# Comment for planning application 22/00959/REM

<b>Application Number</b>	<input type="text" value="22/00959/REM"/>
<b>Location</b>	<input type="text" value="OS Parcel 9100 Adjoining And East Of Last House Adjoining And North Of Berry Hill Road Adderbury"/>
<b>Proposal</b>	<input type="text" value="Reserved matters application pursuant to outline planning permission 19/00963/OUT to discharge all remaining reserved matters (appearance, landscaping, layout and scale), the full discharge of conditions 1, 14, 17, 18 and 20 and the partial discharge of conditions 5, 7, 11, 12, 13, 19 and 23. The outline planning application was not subject to an environmental impact assessment."/>
<b>Case Officer</b>	<input type="text" value="Andy Bateson"/>
<b>Organisation Name</b>	<input type="text" value=""/>
<b>Name</b>	<input type="text" value="Nick and Bronwyn Adams"/>
<b>Address</b>	<input type="text" value="The Gables,Berry Hill Road,Adderbury,Banbury,OX17 3HF"/>

BERRY HILL ROAD, ADDERBURY - DRAFT SITE LAYOUT

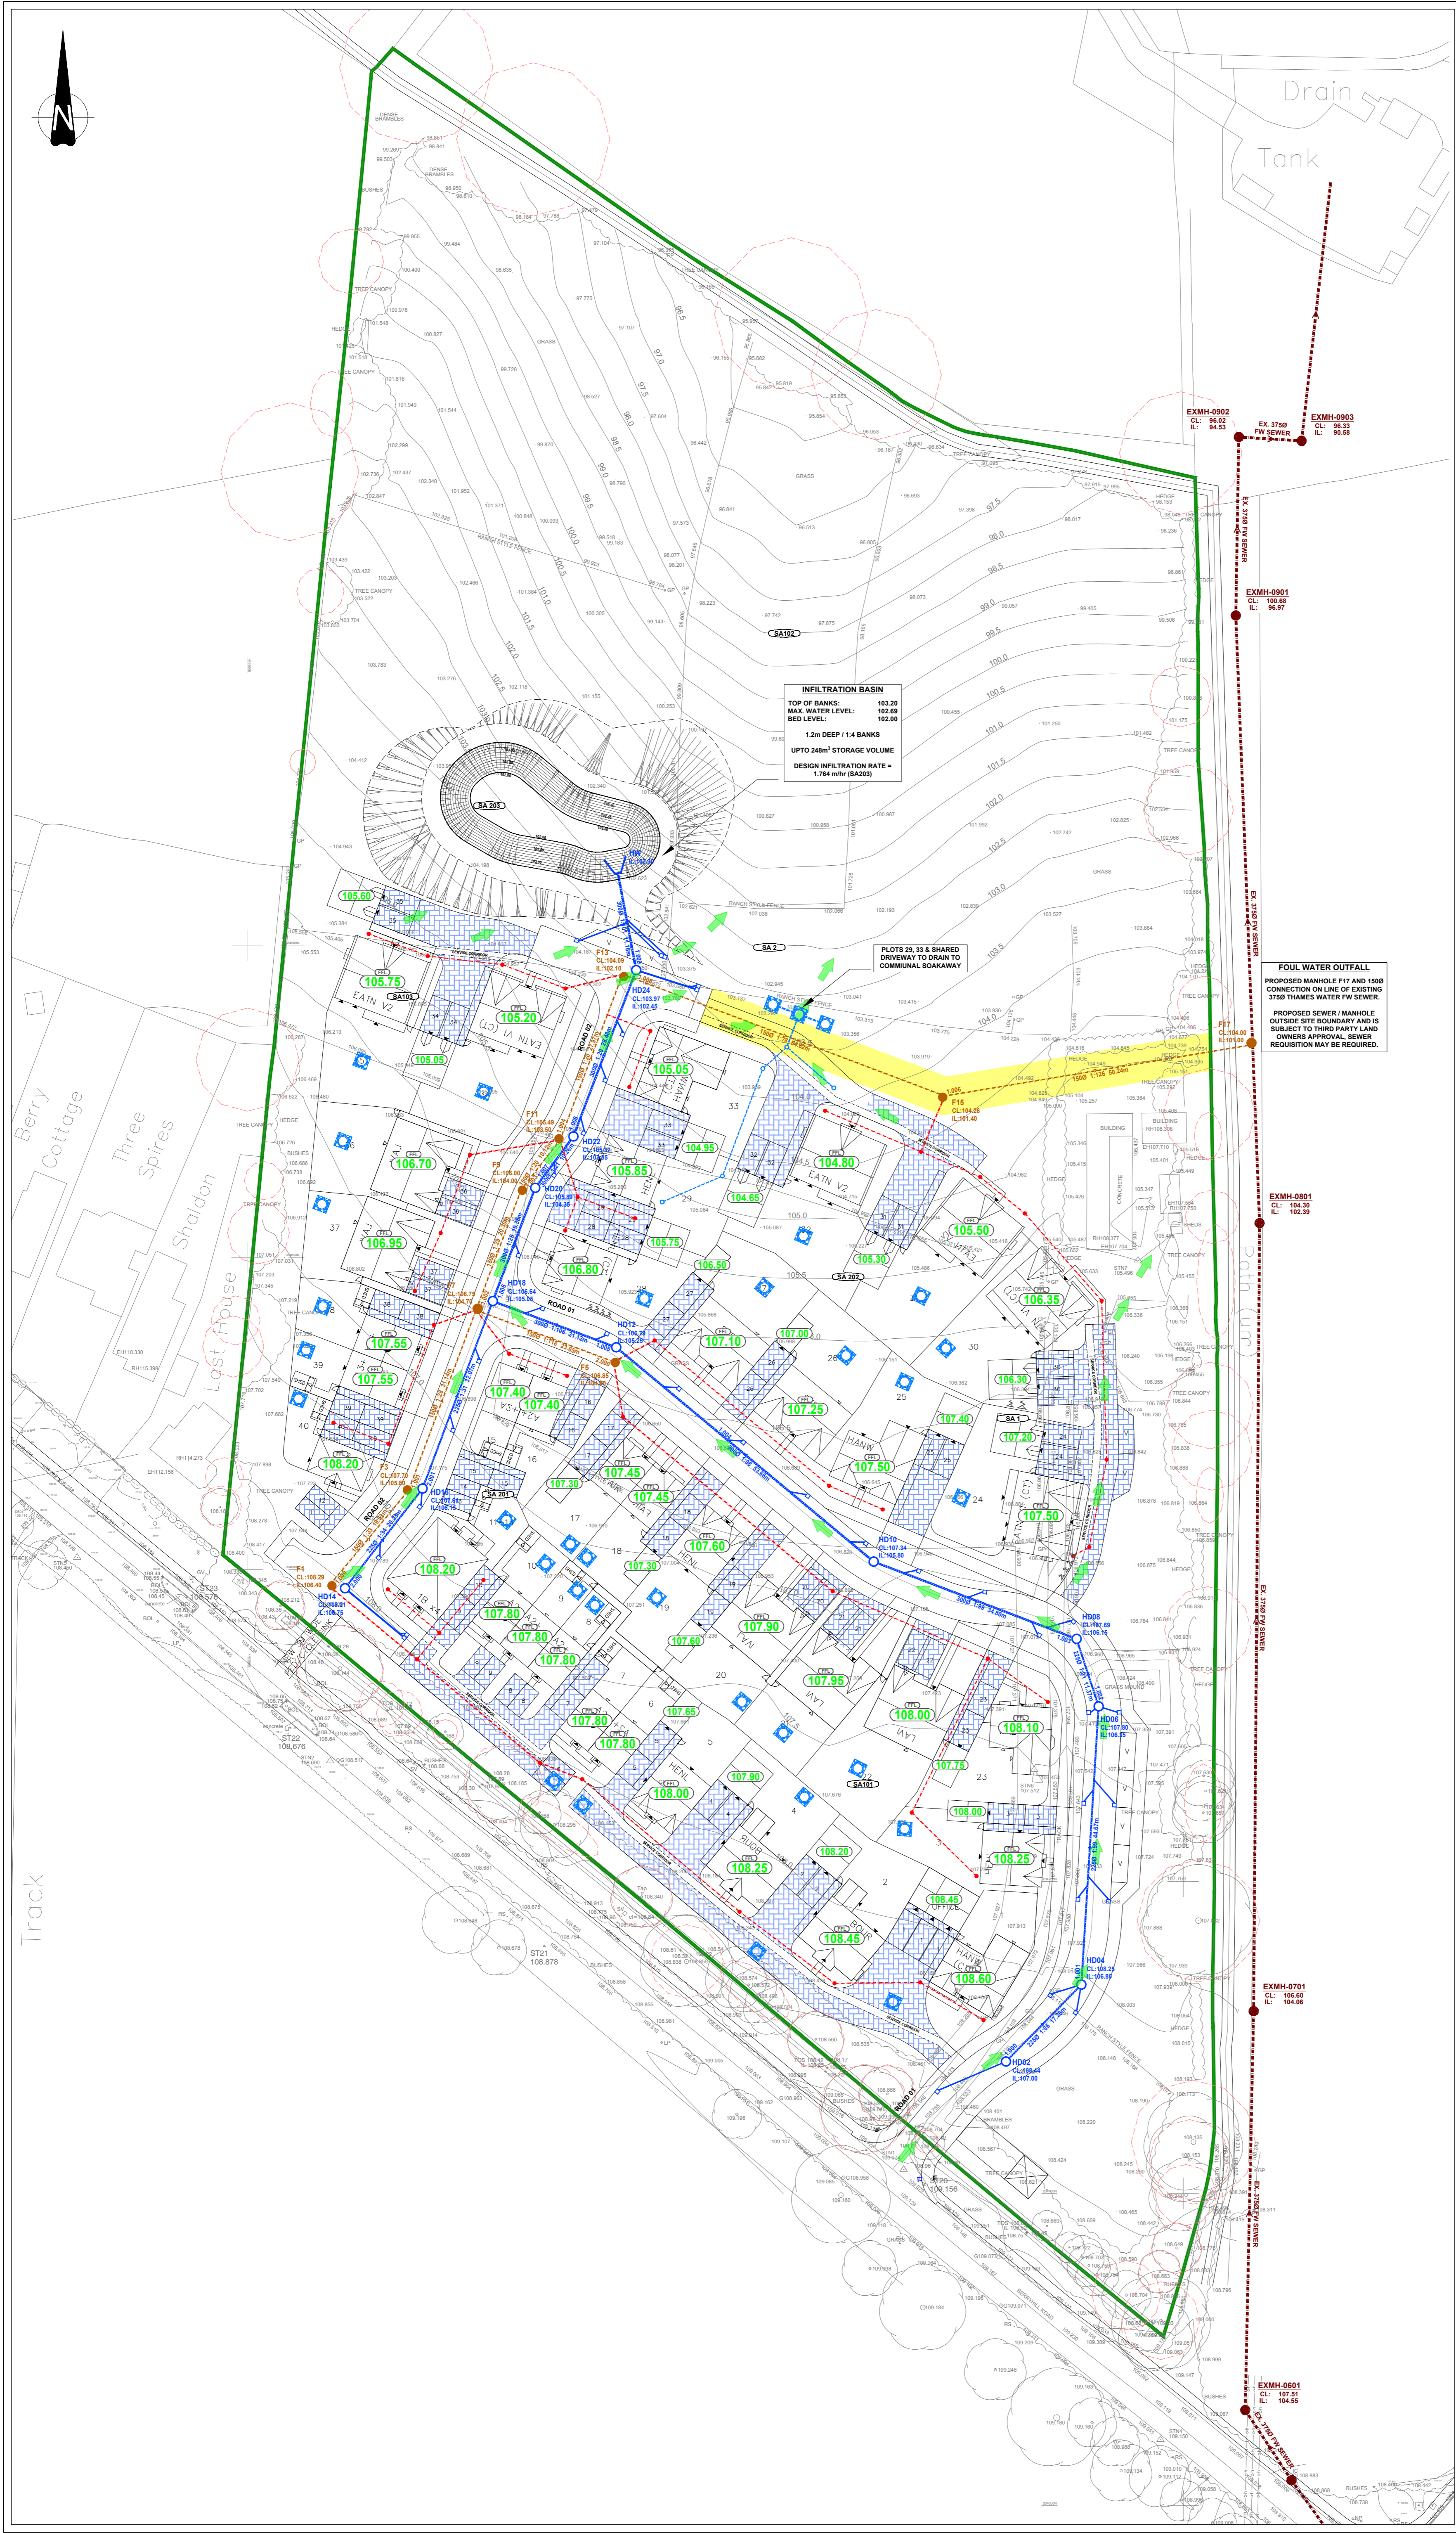
<b>Type of Comment</b>	<input type="text" value="Comment"/>
<b>Type</b>	<input type="text" value="neighbour"/>
<b>Comments</b>	<input type="text" value="This is not an objection as such but a suggested alternative layout that we feel would benefit both the purchasers of the new houses and the existing Berry Hill Road residents; in particular the four properties that would be mainly affected by the close proximity of the new development i.e. Last House, Shaldon, Three Spires and the paddocks and mnage of our property - The Gables. This alternative layout was proposed to the original planning applicants, Hollins Strategic Land, by the Chair of the West Adderbury Residents Association and was fully supported by the residents affected but this new application does not appear to have taken it into consideration. An outline plan is attached. The numbers of houses would not be reduced and the actual built infrastructure and housing would be maintained as it is. The significant change that is proposed would be that the ecological corridor and any swales required for surface water attenuation would be between the existing ribbon housing that exists along the entire length of Berry Hill Road and the new housing that is proposed."/>
